From Sarah Bucks, chair of the South Somerset Bridleways Association

Response to Deadline 2,

Responses to questions in table 2:

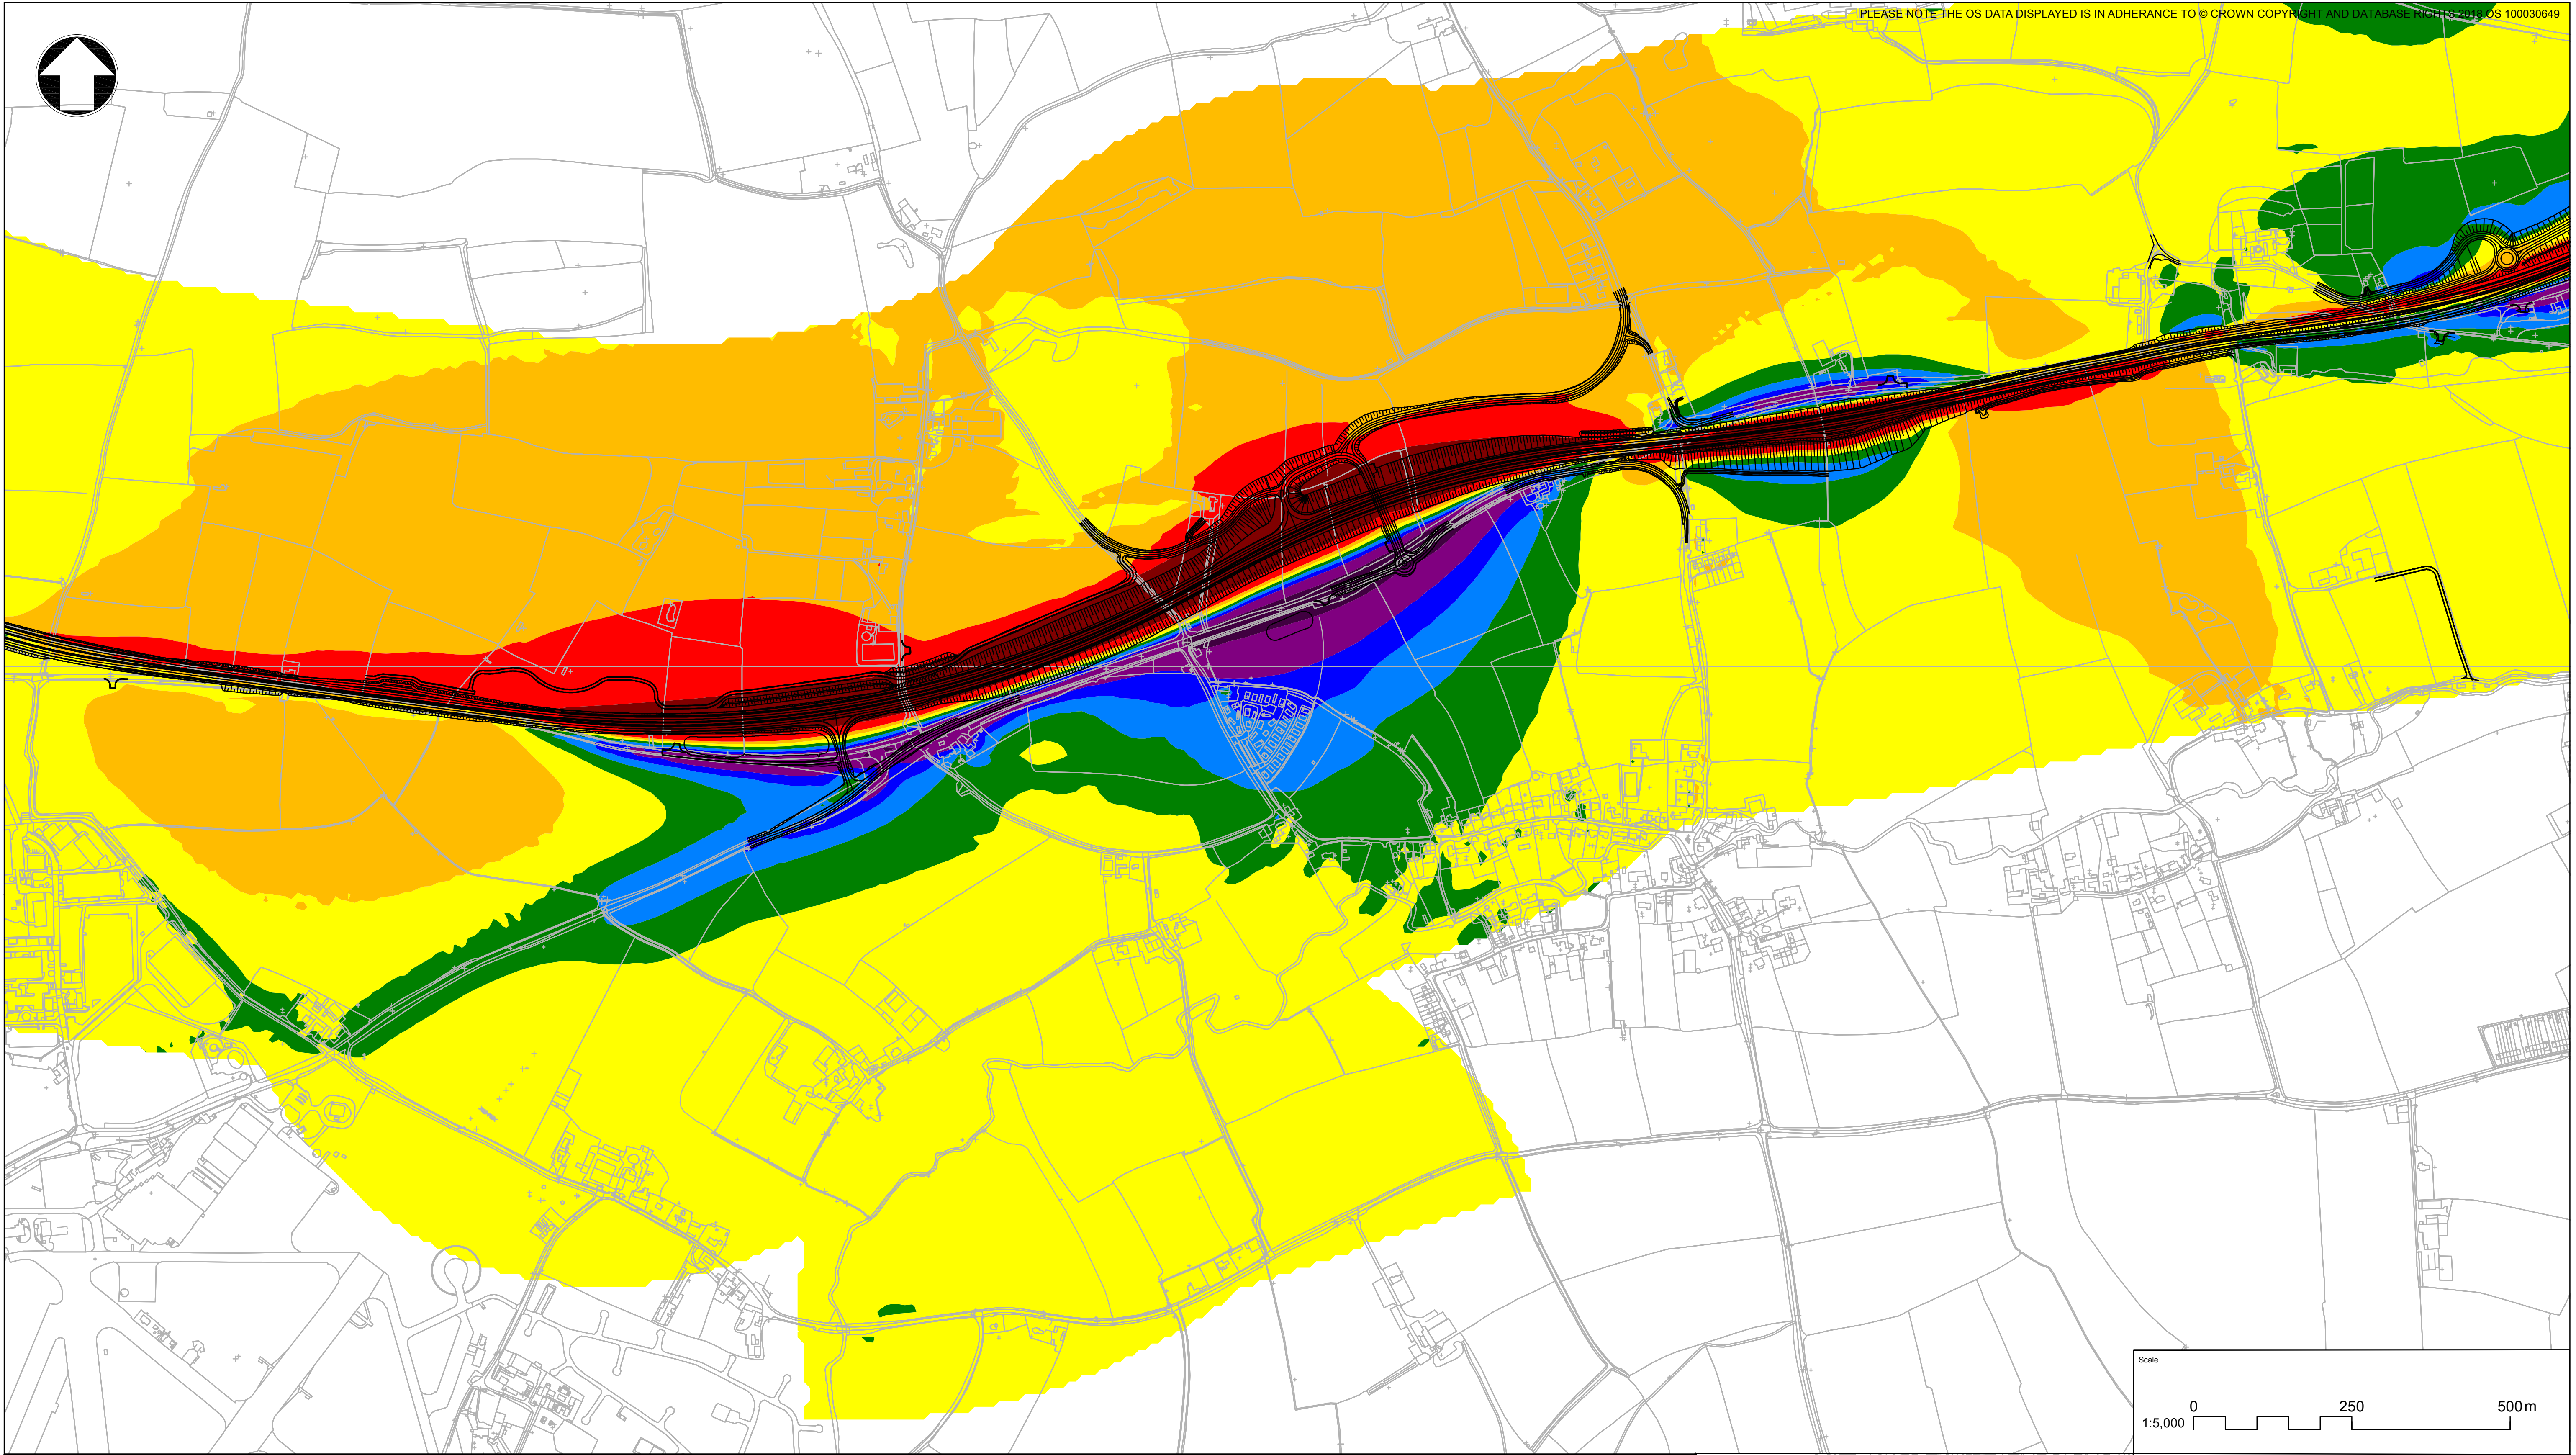
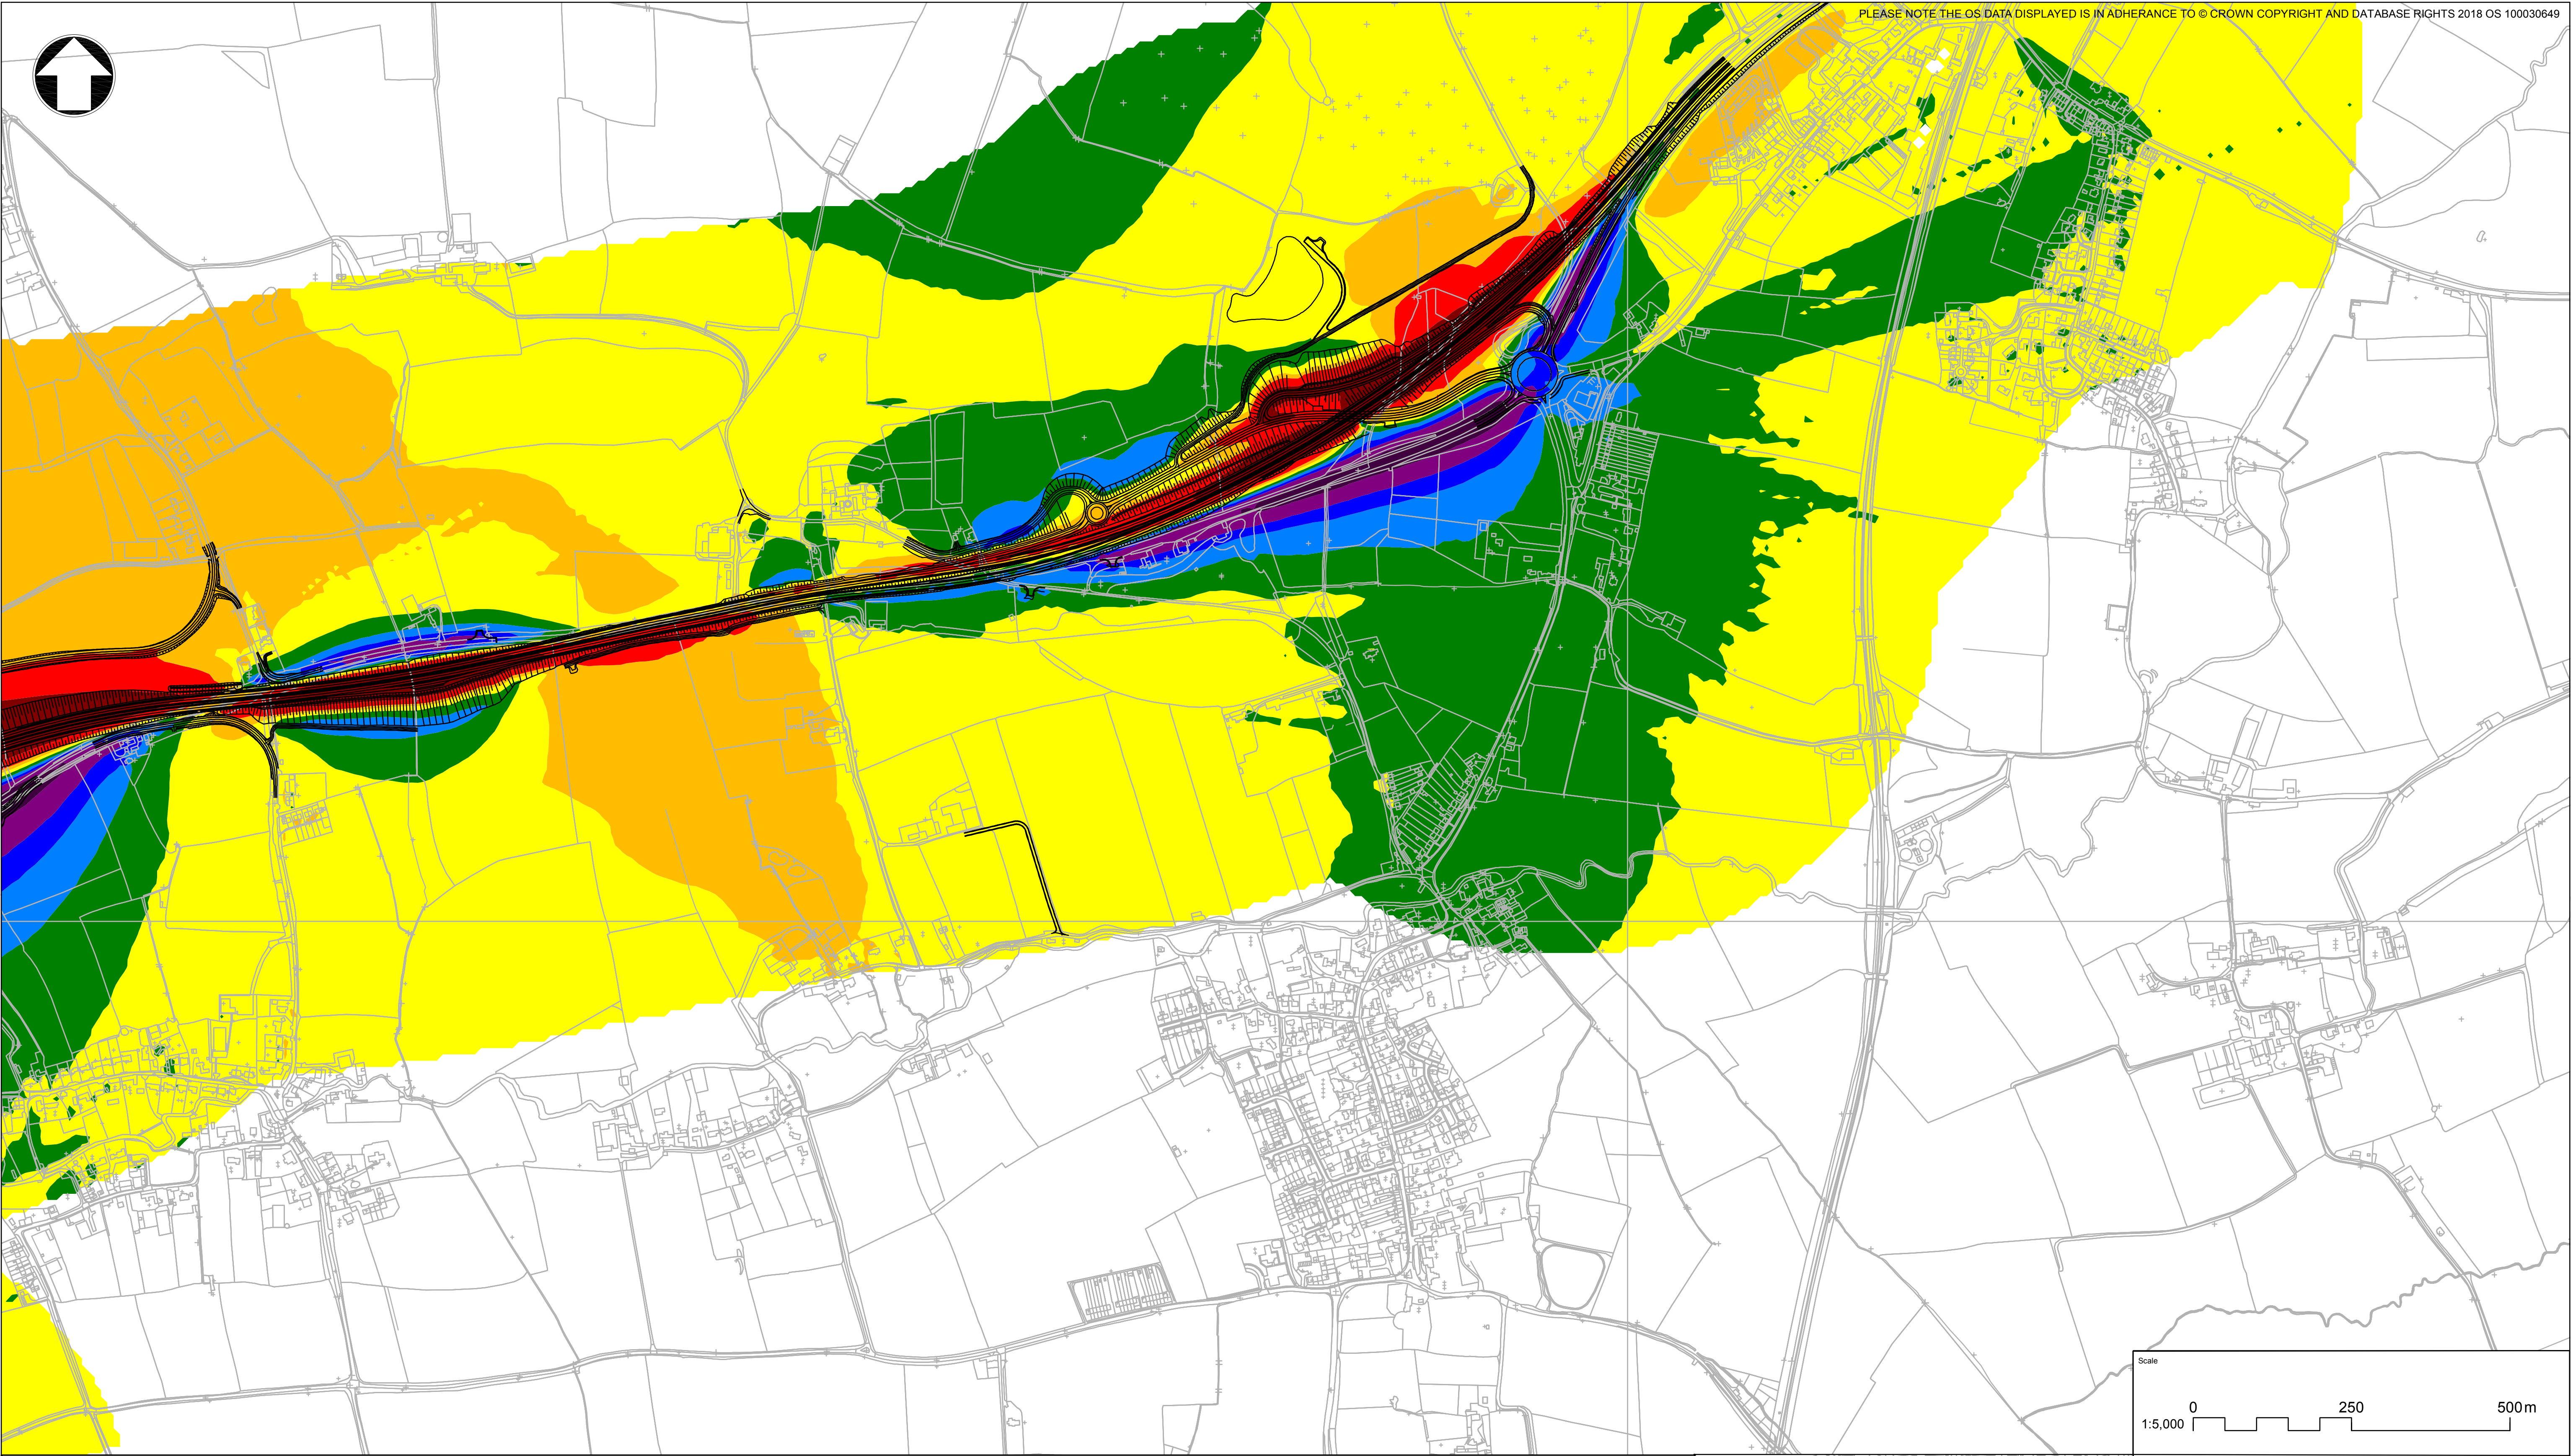
1.4 Road noise along the new carriageway northwest of the Hazlegrove roundabout will impact on the users, including equestrians, of the underpass below. Please could consideration be given to having a low noise surface within the vicinity of the underpass.
